NDA submission for the DART+ West Project

The NDA welcomes the opportunity to make a submission to An Bord Pleanála concerning the DART+ West project and railway order, which is being managed by Irish Rail.

- Proposed Pedestrian and Cycle Bridge.

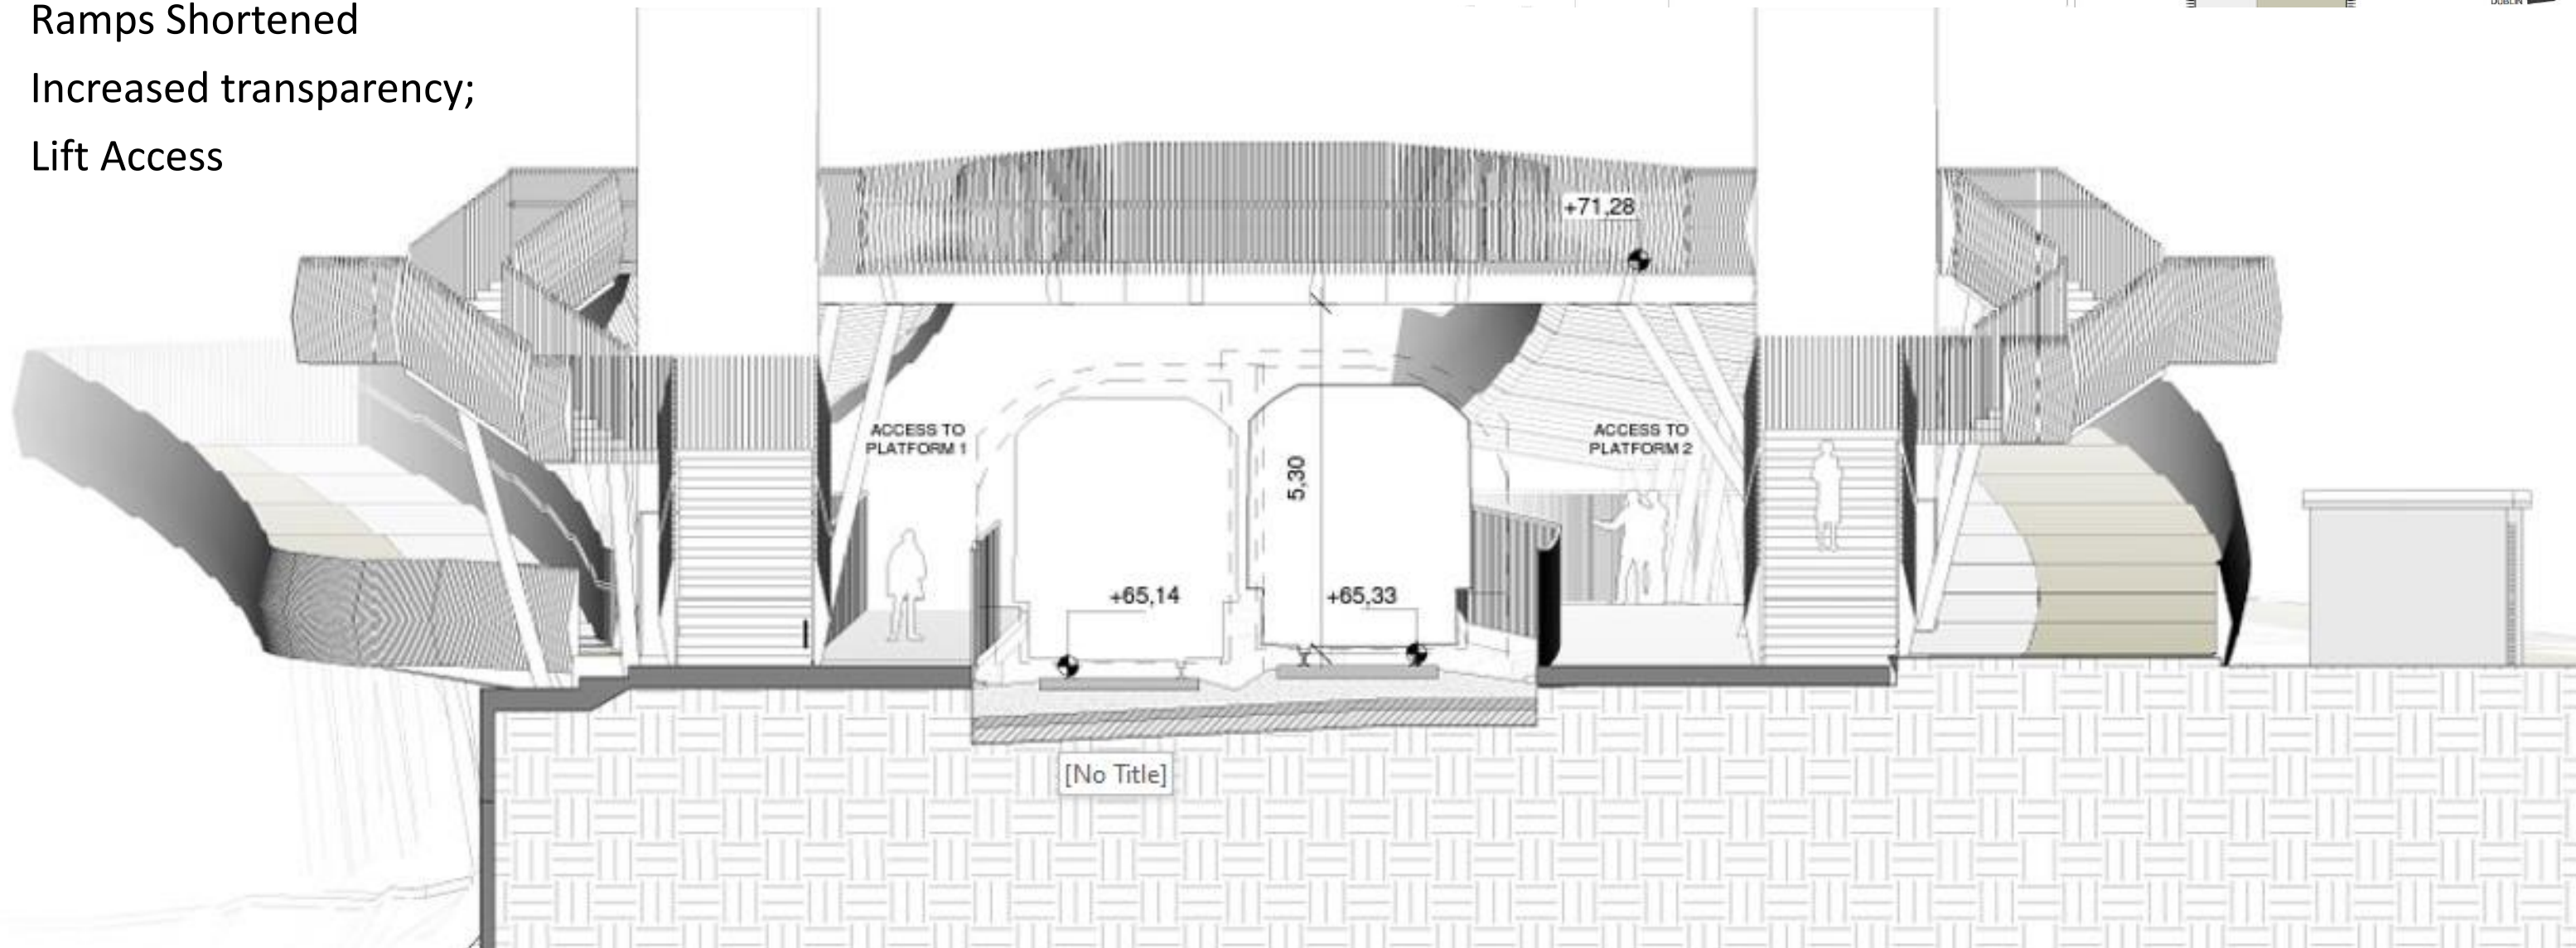
In 2021 it was brought to the NDA's attention that the newly opened train station at Pelletstown was highlighted by several Disabled Persons Organisations (DPOs) and other stakeholders as having poor accessibility. While ramps were installed at this stations, these ramps are very long due to the height of the pedestrian bridge over the platform and present barriers to accessibility for a lot of people, particularly wheelchair users, and people with health or mobility related issues which would make climbing steps or taking a long ramp difficult. A key issue highlighted was the absence of any lifts at the station. When this issue was raised with Irish Rail, the NDA was told that the ramps provided are in compliance with Part M of the building regulations and that there were no plans to install lifts in this station. However, TGD M and standards such as BS8300 and IS EN17210 all note that where the rise of a ramp is greater than 2000mm, an alternative means of access for wheelchair users (such as lifts) should be provided. Ramps beyond this height become too tiring for wheelchair users.

The NDA therefore, notes with concern that a similar design has been put forward for the update to Ashtown station, again with the provision of steps and ramps, but no provision of lifts.

The NDA recommends that this current design is re-visited and that DPOs and persons with disabilities are consulted at all design phases when determining an alternative design. The NDA and CEUD are happy to provide further information and advice as required. The NDA wishes to point out requirements under the Disability Act (separate to building regulations) which should be considered in designing transport infrastructure;
